From: James Cross <James.Cross@arun.gov.uk>
Sent: 21 November 2019 16:16
To: Planning.Responses <Planning.Responses@arun.gov.uk>
Subject: FW: BR/256/19/PL - 2 Cavendish Road, Bognor Regis, PO21 2JW

Conversion of existing store to 2 bed dwelling to the rear of 2 Cavendish Road, fronting Sutherland Close.

Proposed Roof Plan

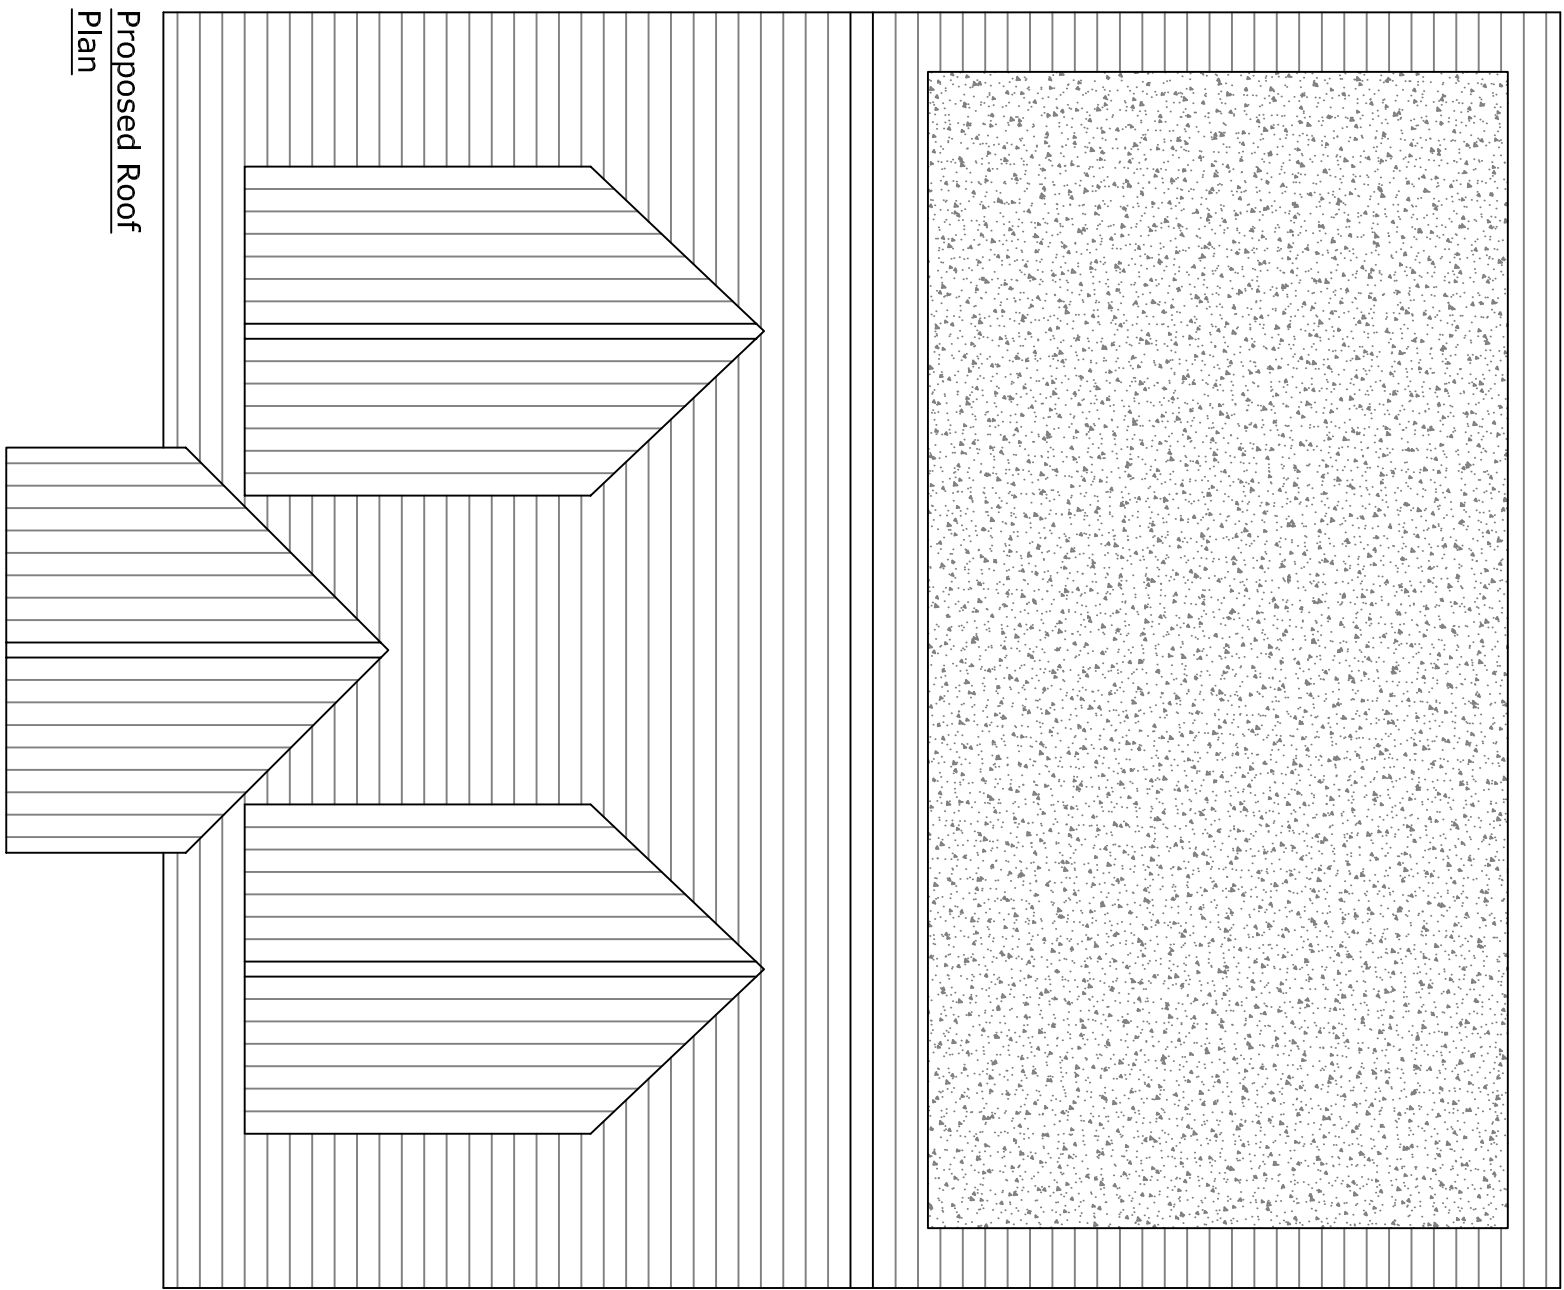
Many thanks for bearing with me over the weekend whilst I took the time to discuss the proposals with my management and Simon. In terms of the submitted 3 bedroom design, and owing to the previous planning histories on the site dating back to 2011, we would have concerns with the rear dormer window and it's proximity to the property to the south, combined with the potential for over massing impacts. Further, we would also have concern relating to privacy deriving from overlooking to the rear garden spaces of properties to the south. Whilst I appreciate that this is somewhat disappointing news, it is with regret that we would be unable to support the application in its current form.

I noted from our previous email correspondence your desire to work with the Local Authority to achieve a development on this site. Having discussed possibilities with management, we would be happy for you to remove the rear dormer window and utilise velux style rooflights, positioned 1.7m above FFL. This would result in a reduction in bedrooms from 3 down to 2. This would provide a development of kinds on the site, which would overcome the concerns raised.

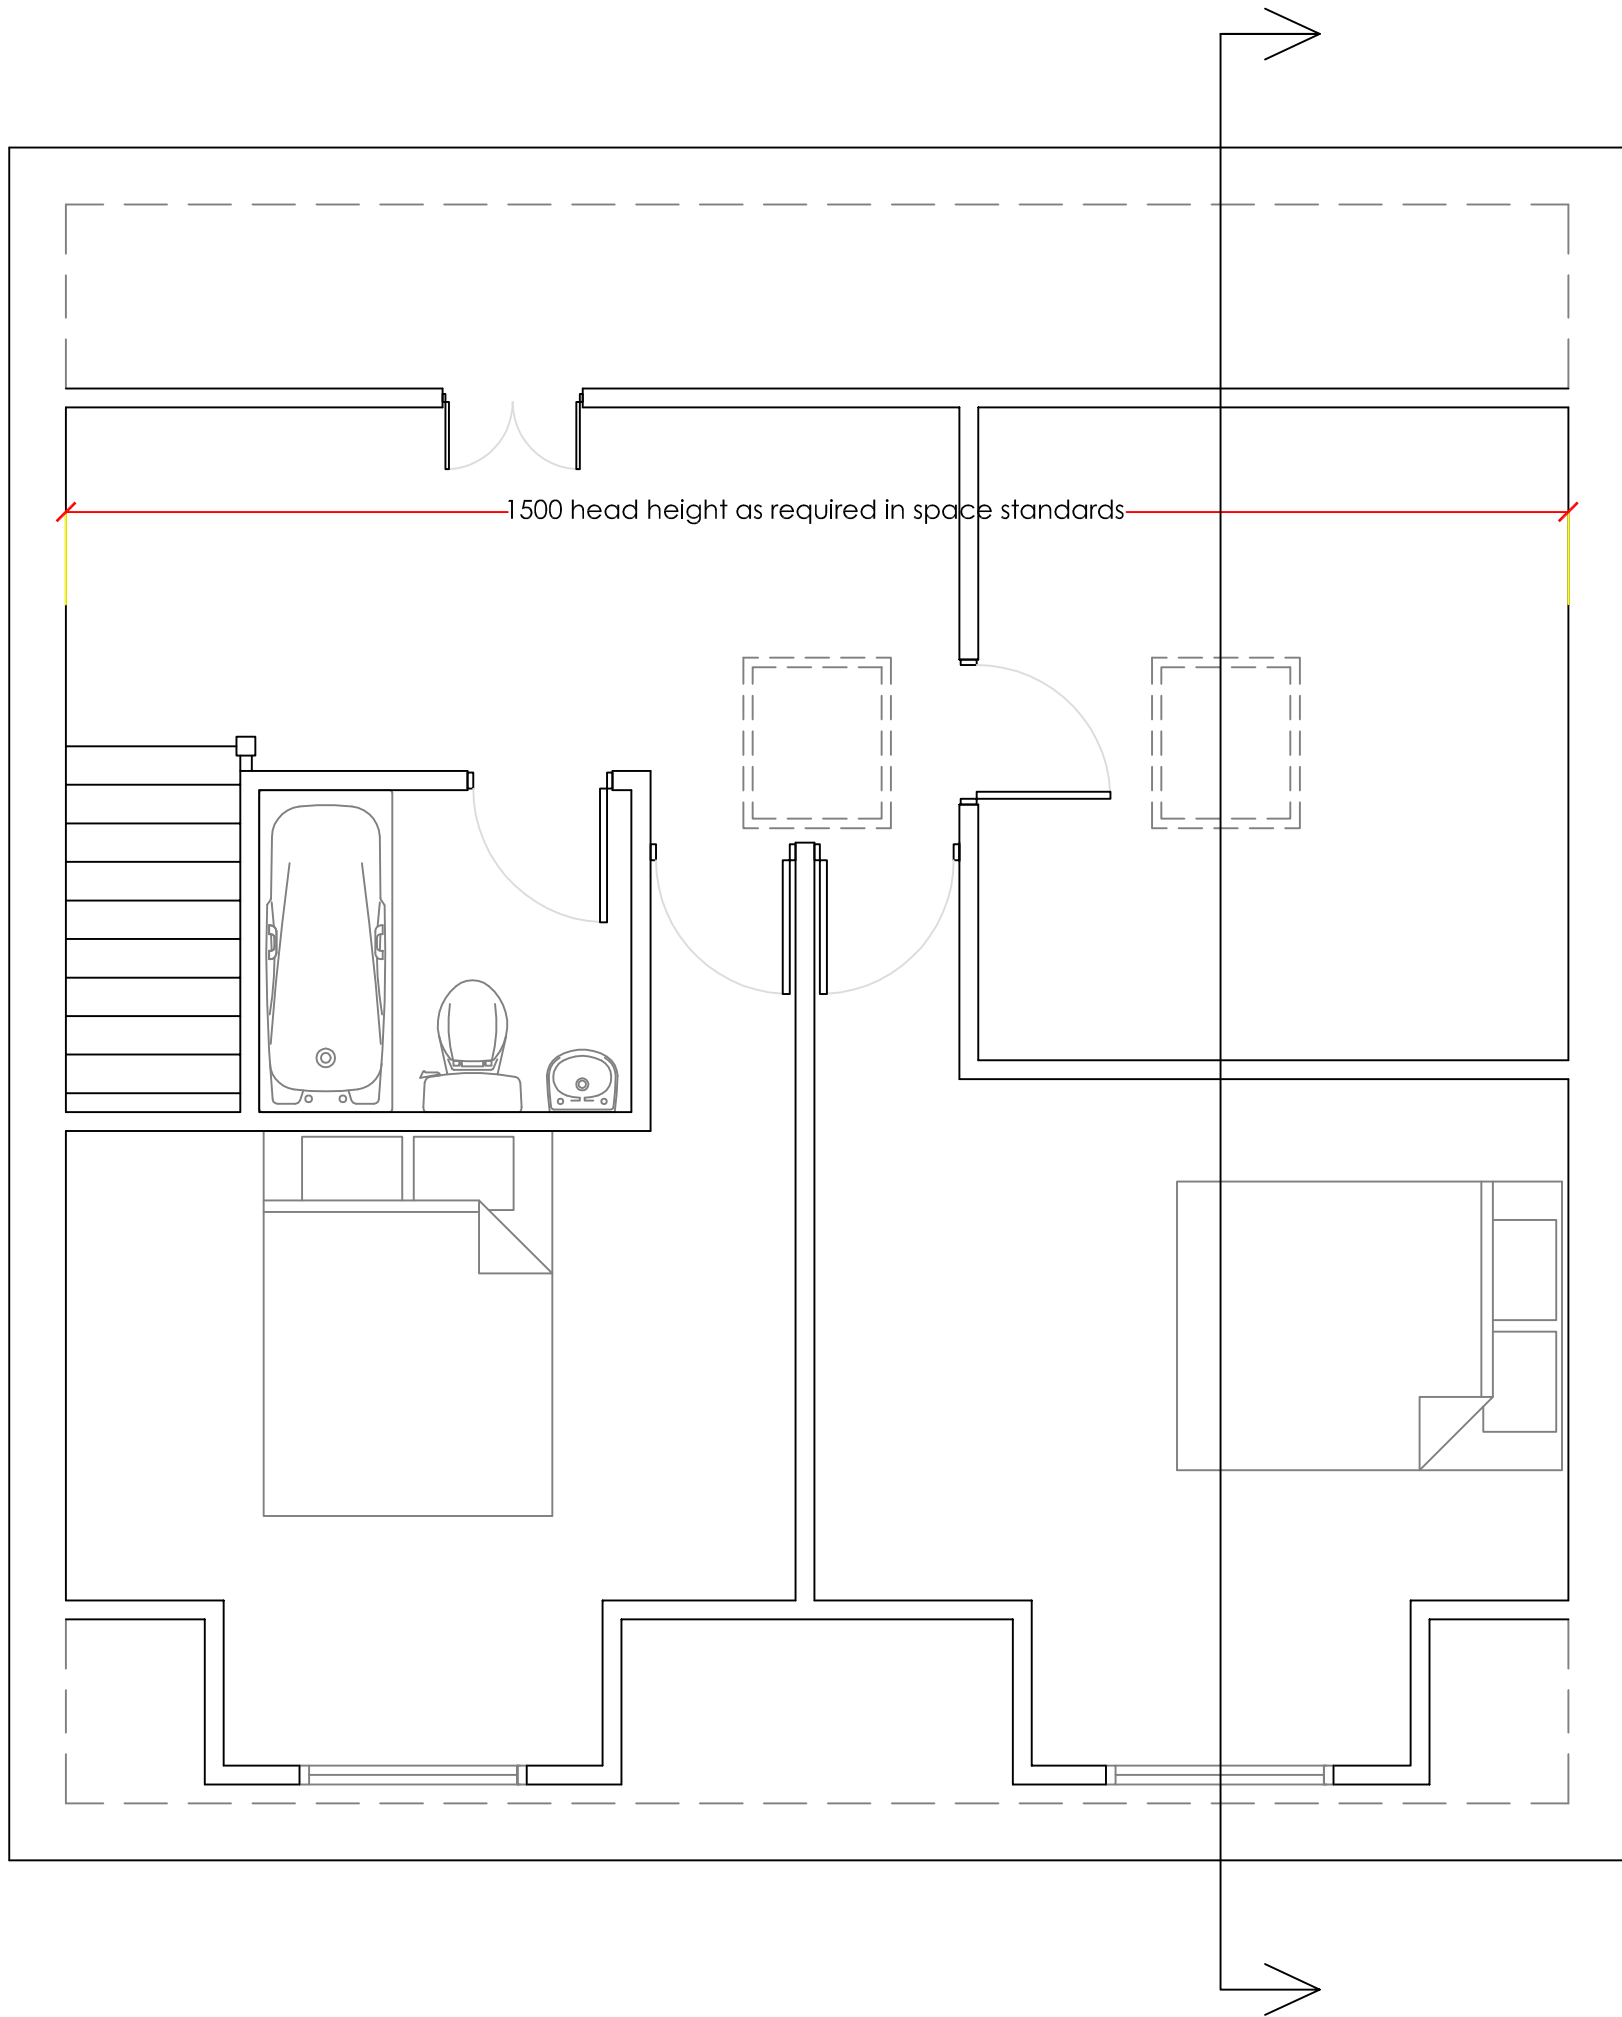
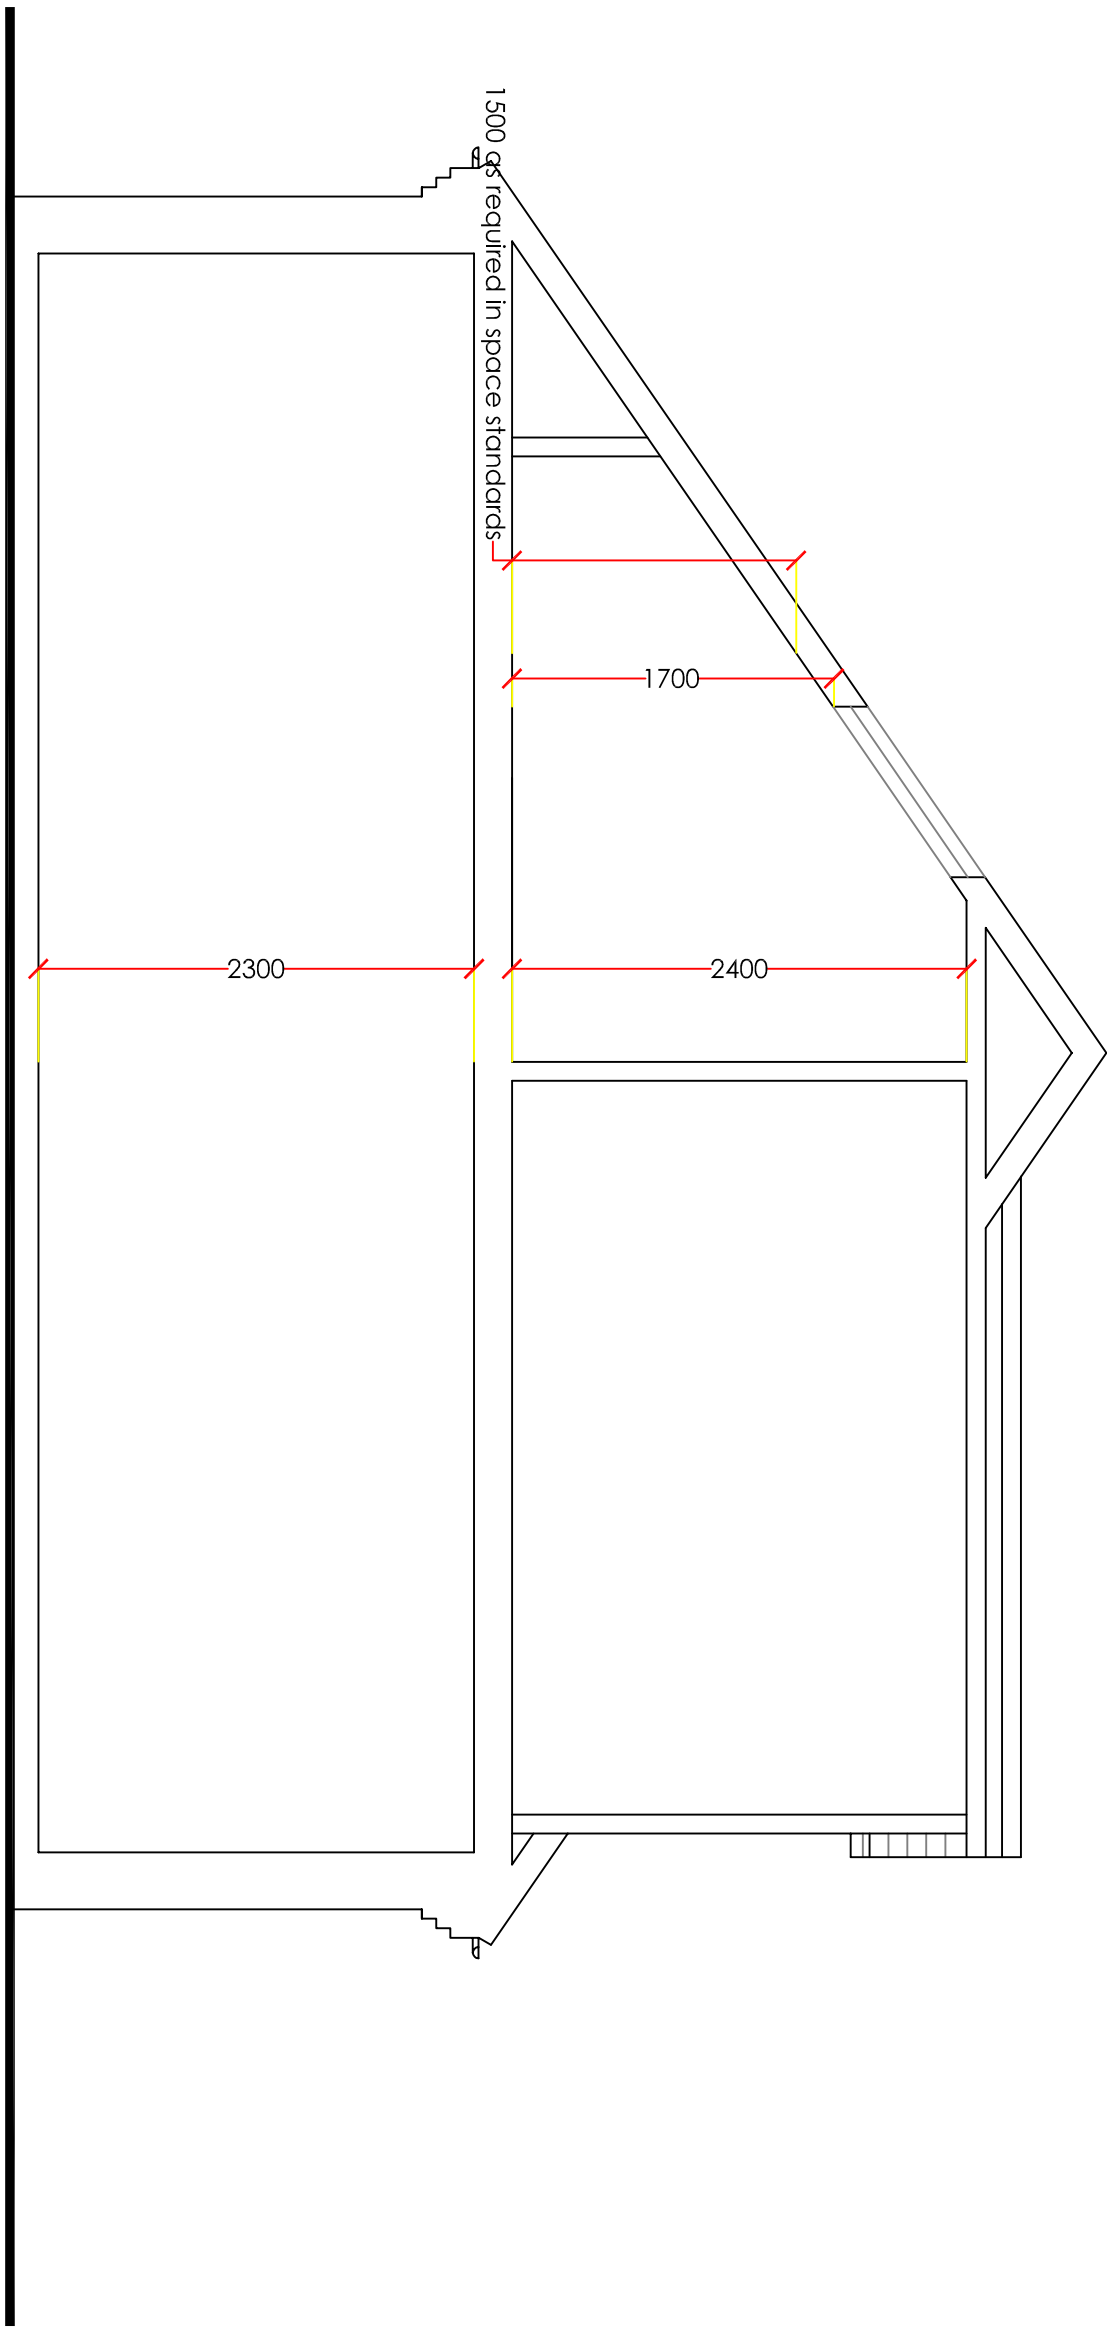
1. Could you provide an internal section to show how the pitch of the roof impacts upon internal spaces in the rooms to the rear? I envisage significant concern will be raised given that what is in effect a bedroom is shown to the rear. I will obviously need to assess this as such against internal space standards etc. I also need to be satisfied, through the submission of a section, to ensure the velux rooflights are 1.7m above FFL to overcome issues of overlooking etc...

Please find attached as discussed, please see notes on plans showing that bed 3 falls within space standards. We are happy to extend the determination deadline. Please do not hesitate to contact me if you require any further info.

Proposed First Floor Plan

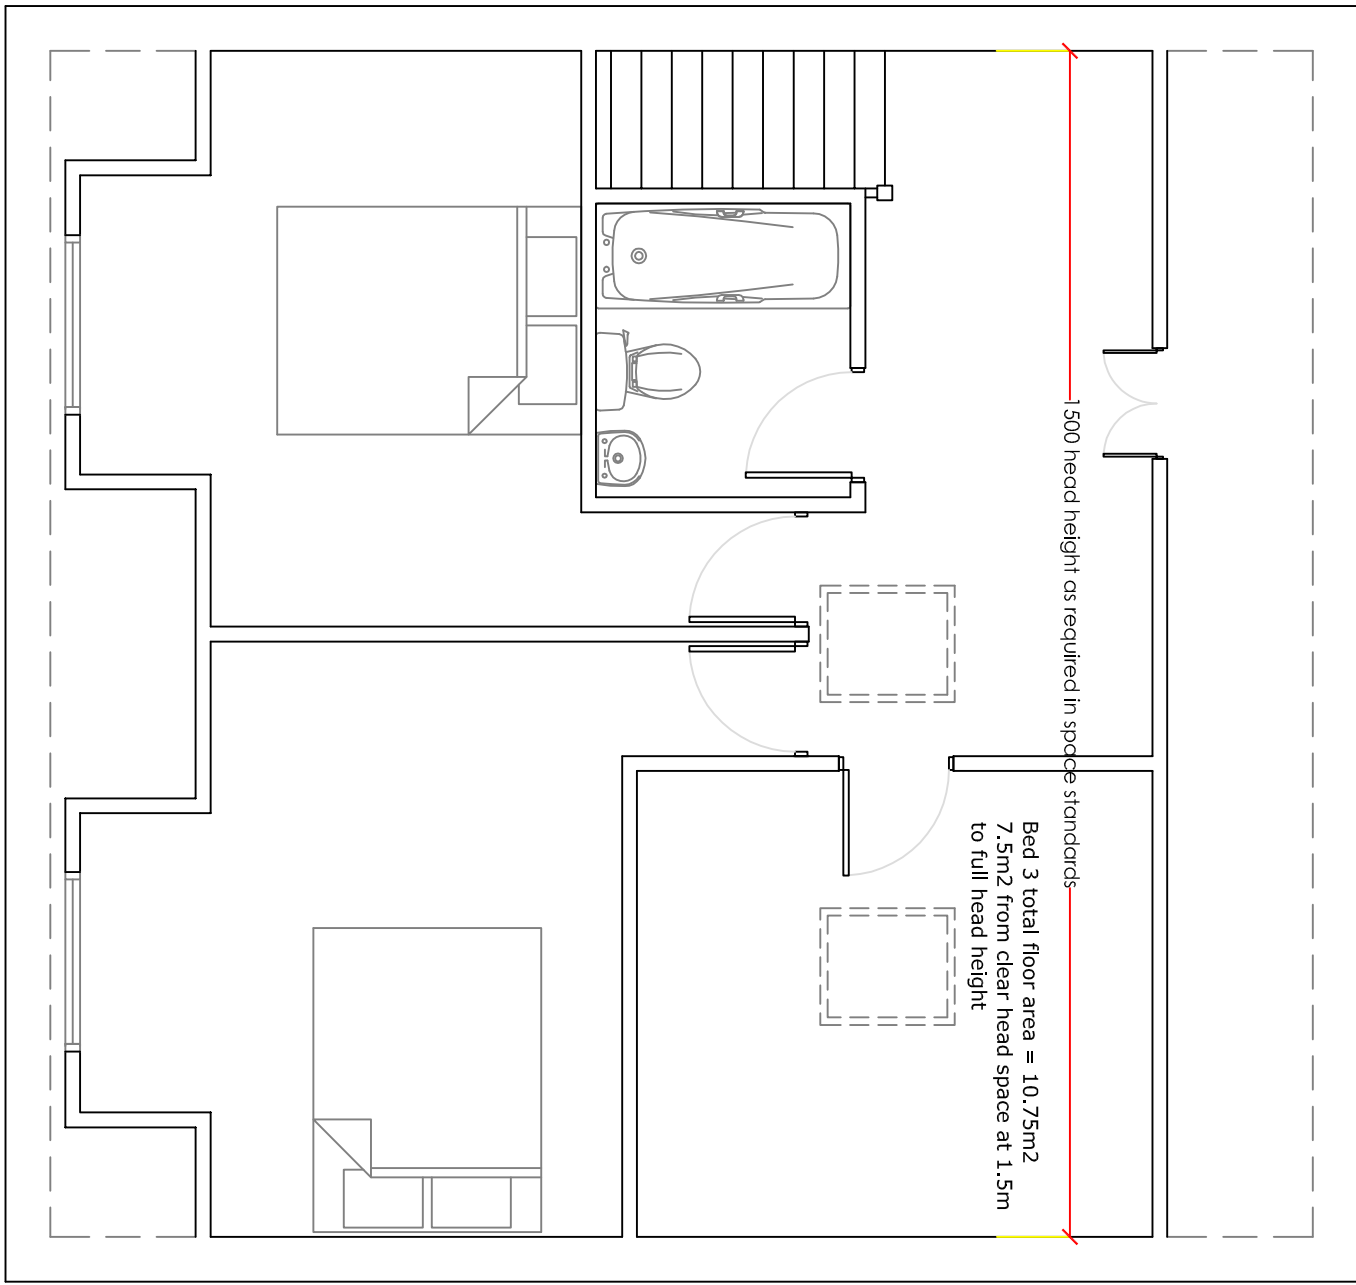
2. Could you please provide a line on the plans showing where the pitch of the roof cuts into the headspace? This will allow me to have a better understanding of how much internal space is usable.

3. Please label the third room accordingly – if this is intended on being a bedroom, please show it as such. If it is to be a study or a snug etc... then please label/furnish accordingly. This is to provide all parties with sufficient clarity in moving forward. I envisage if this were to be a bedroom then it would not likely meet with internal space standards.
